Department of Primary Industries

OUT13/17794

Thank you for your email of 8 July 2013 concerning the review of the Agricultural Impact Statement for the proposed Northparkes Mines Step Change Project.

Specific Agricultural Impact Assessment Issues – Northparkes Mines Step Change Project

FIGURE 5.1

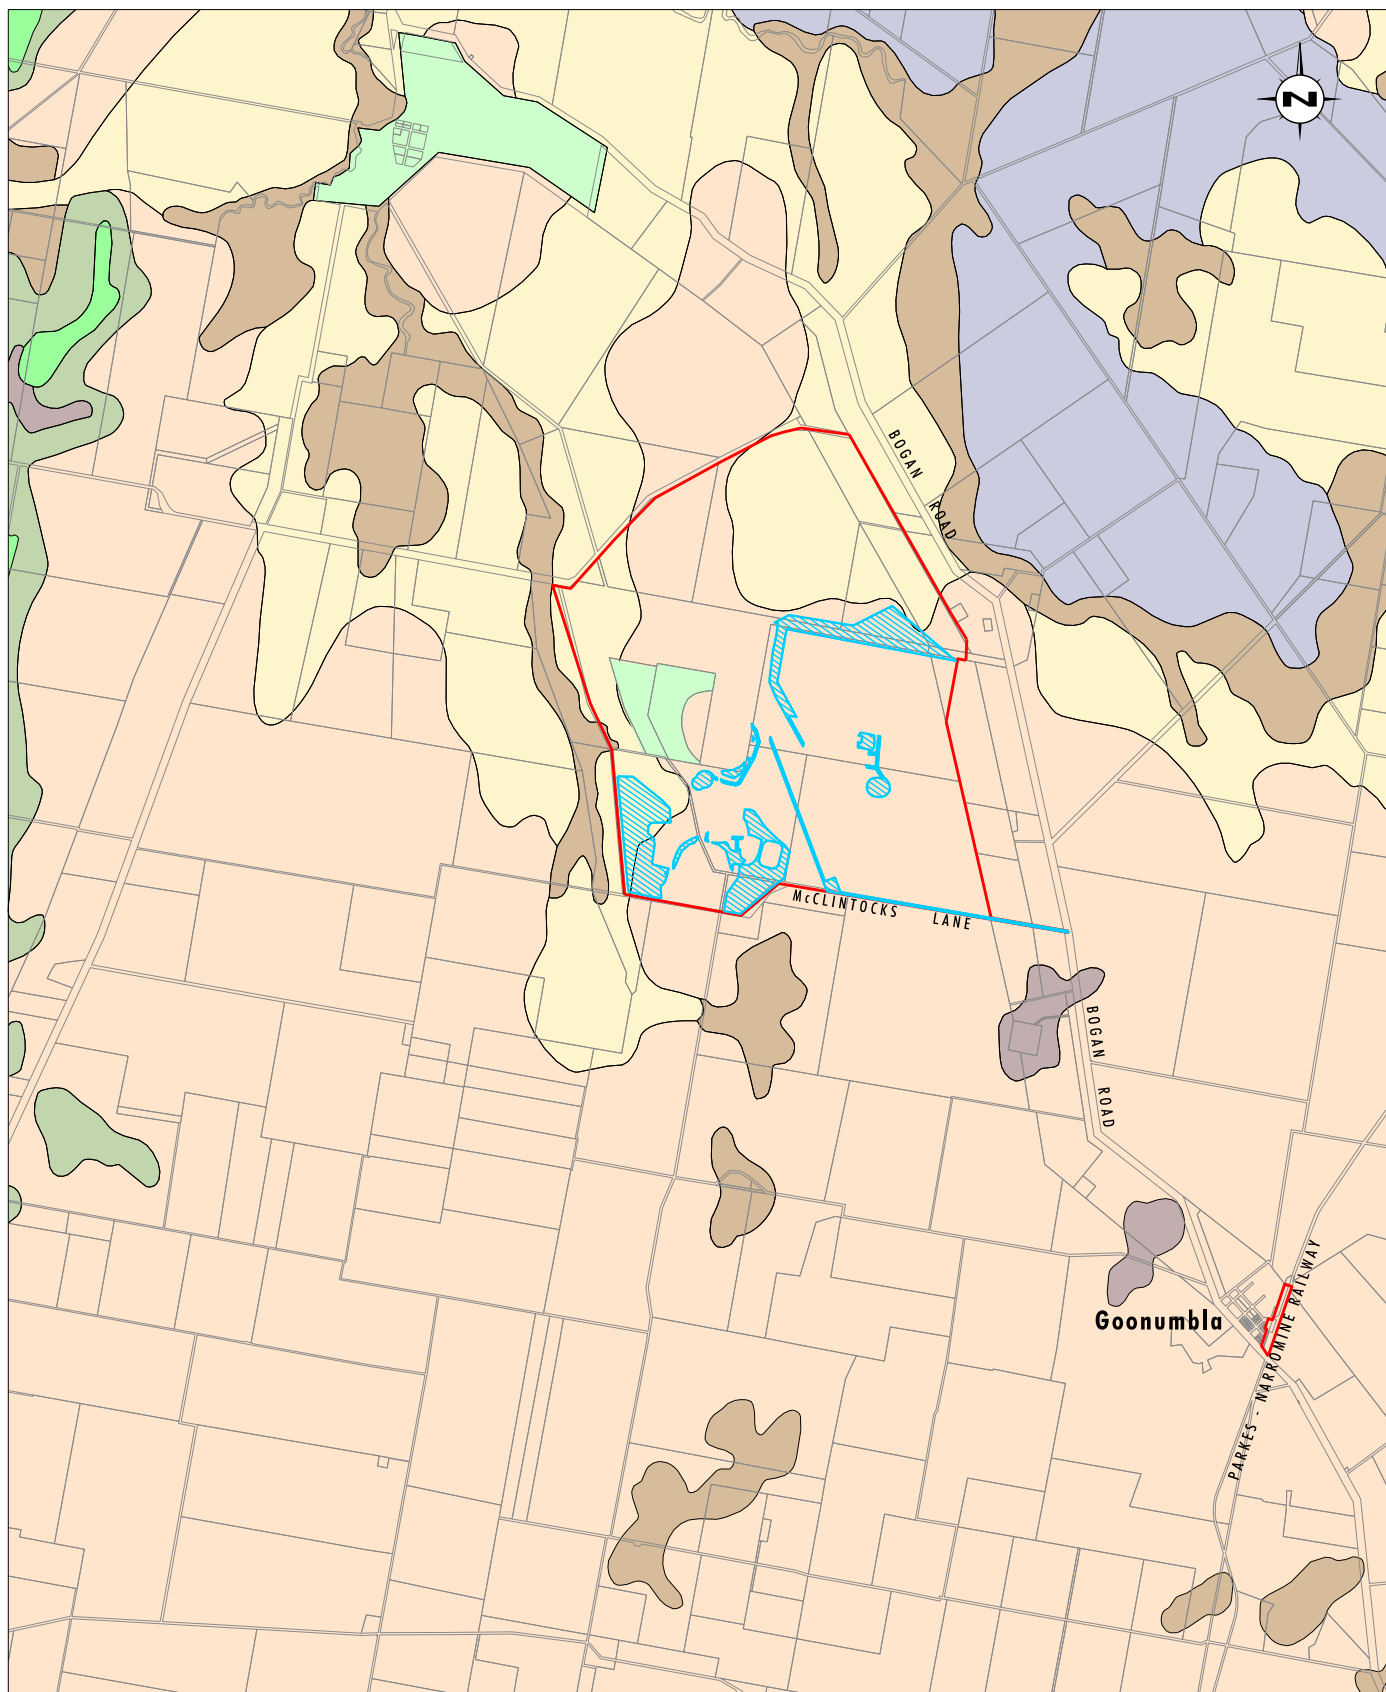
The OAS&FS notes that the project area comprises mainly high quality agricultural land capability classes II and III. Considerable reference has been made to Cunningham (2006) Soils Survey and Land Capability Assessment of the Northparkes Mines – E48 Project yet this document has not been included. Without this information, soils and land capability cannot be properly assessed. The OAS&FS requests the inclusion of this document or the inclusion of the relevant data referred to in this document.
